CITY OF ALBUQUERQUE

December 10, 2018

Re: Car Wash Lomas
9935 Lomas Blvd NE
Traffic Circulation Layout
Engineer's/Architect's Stamp **11-29-18** (J20D003)

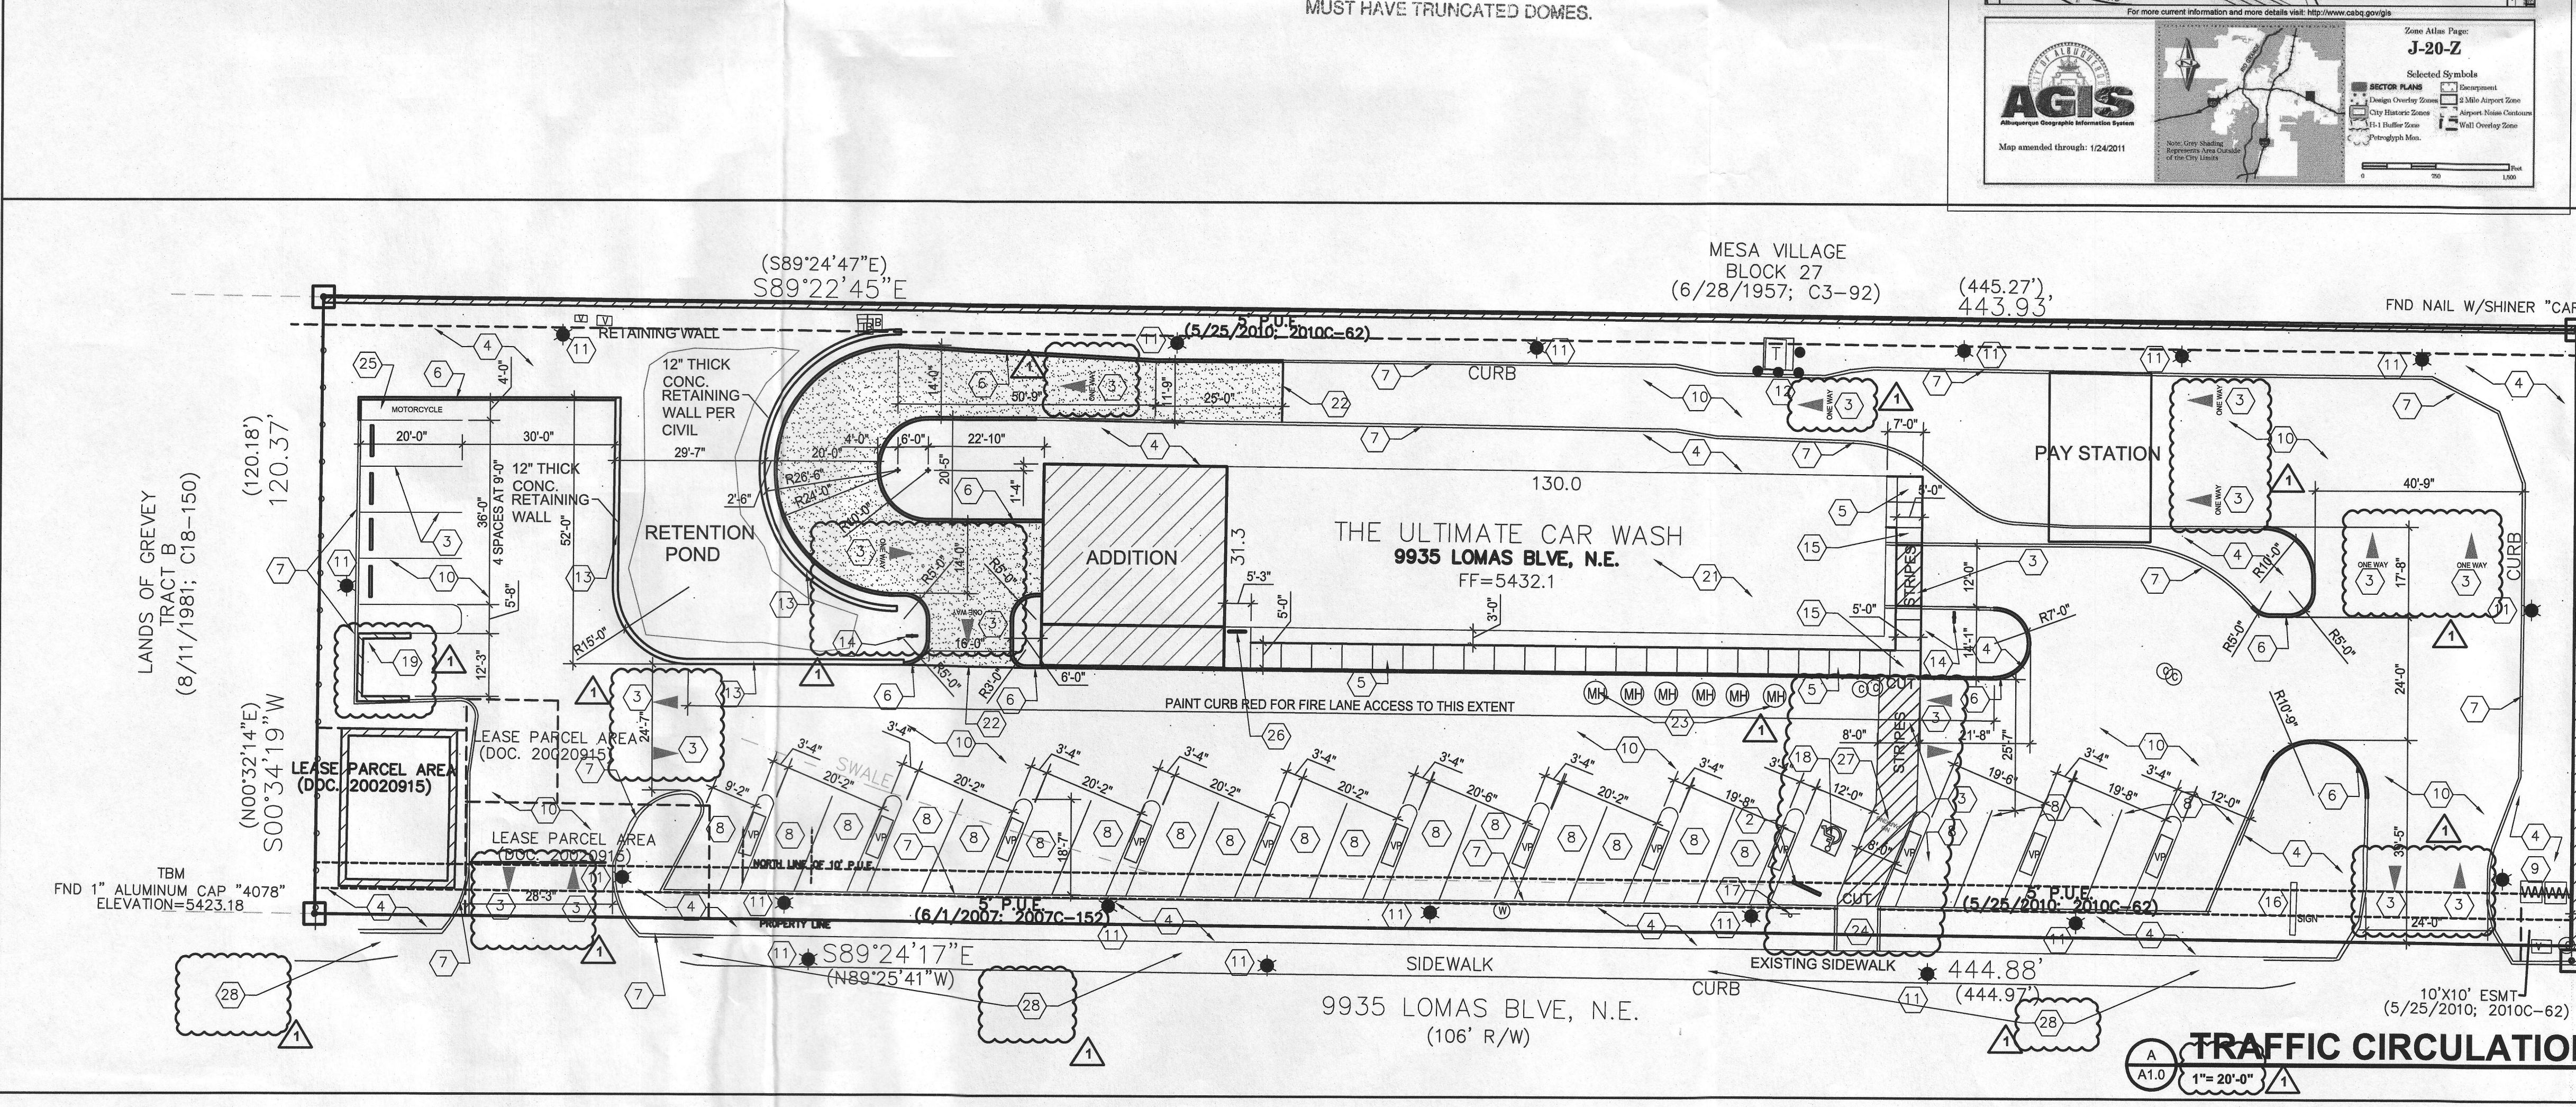
1. The traffic circulation layout must be stamped, signed, and dated by an engineer or architect licensed in the state of New Mexico.
2. The scale must be shown on the plan. Per the Development Process Manual, Chapter 27, Section 2, Part B.1, on the following scales may be used:

$1" = 20'$
 $1" = 40'$
 $1" = 100'$ (for overall layouts only)
3. The ADA access aisles shall have the words **"NO PARKING"** in capital letters, each of which shall be at least one foot high and at least two inches wide, placed at the rear of the parking space so as to be close to where an adjacent vehicle's rear tire would be placed. (66-1-4.1.B NMSA 1978)

4. Service vehicle and/or refuse vehicle maneuvering must be contained on-site; provide a copy of refuse approval.
5. Signing, Striping: Adequate signing (one-way, do not enter, etc.) and striping needs to be incorporated into the design of the parking area which will help to convey to the motorist the proper use of the facility

6. Add a note stating "All broken or cracked sidewalk must be replaced with sidewalk and curb & gutter." A build note must be provided referring to the appropriate City Standard drawing.
